CITY OF PORTLAND, MAINE

PLANNING BOARD

May 24, 2016

Project Name: India Newbury Residences
Address: 62 India Street
Applicant: India Newbury Residences, LLC
Planner: Caitlin Cameron

A-1.1

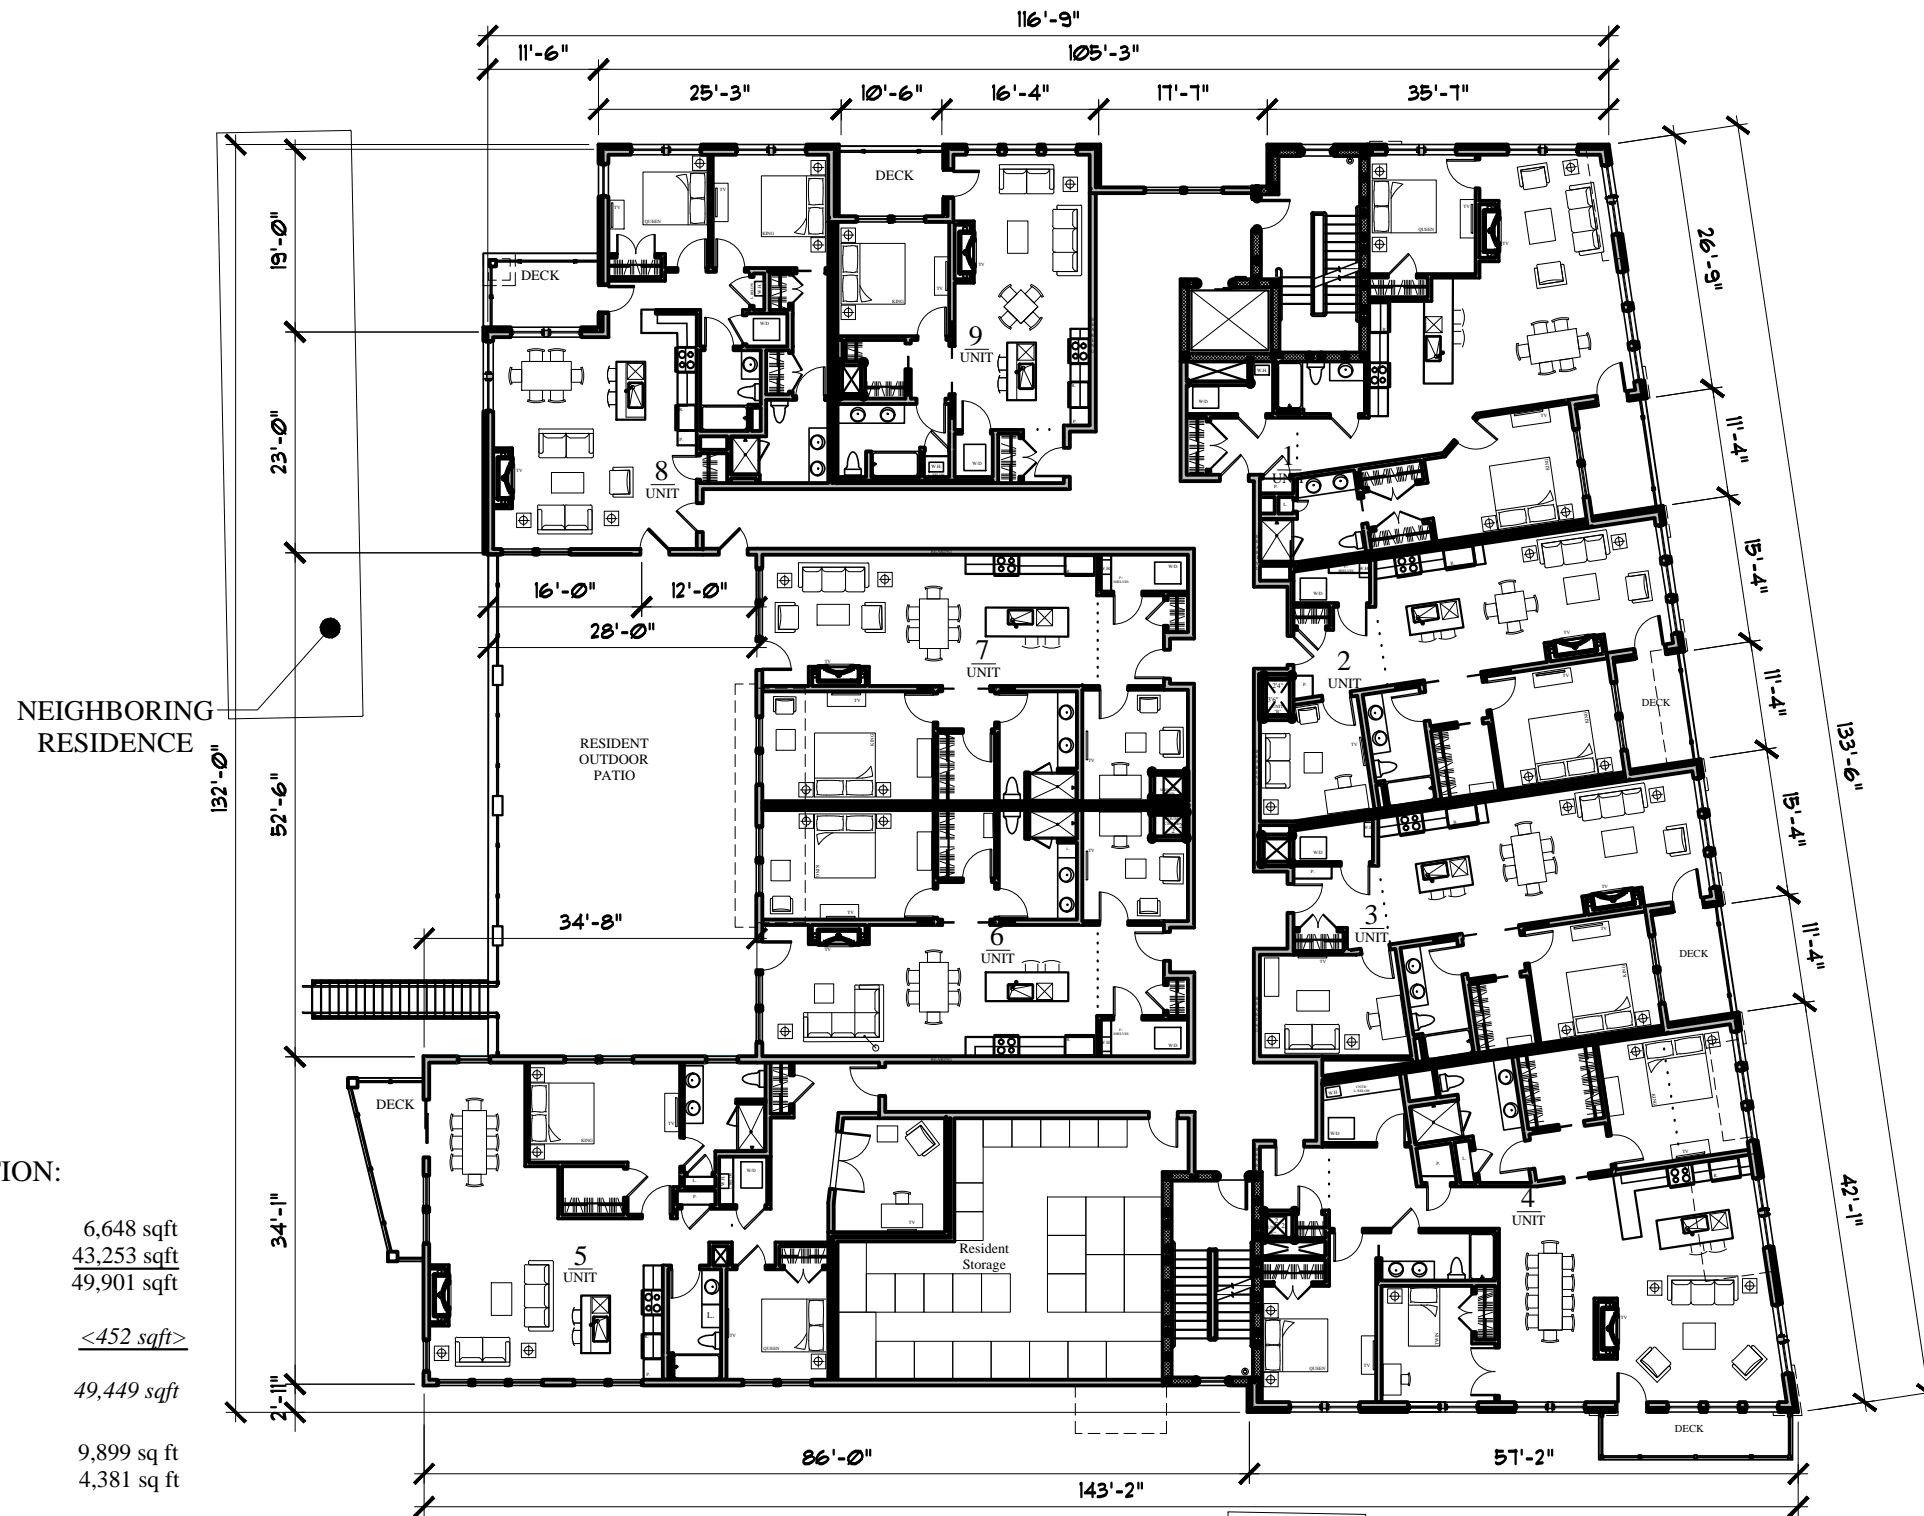
4. The approved drawing set shall be revised to reflect the correct building area calculations;
5. The applicant shall provide drafts of all necessary easements, for review and approval by Corporation Counsel, the Department of Public Works, and the Planning Authority, with evidence of executed easements to be submitted prior to the issuance of a building permit, including but not limited to:
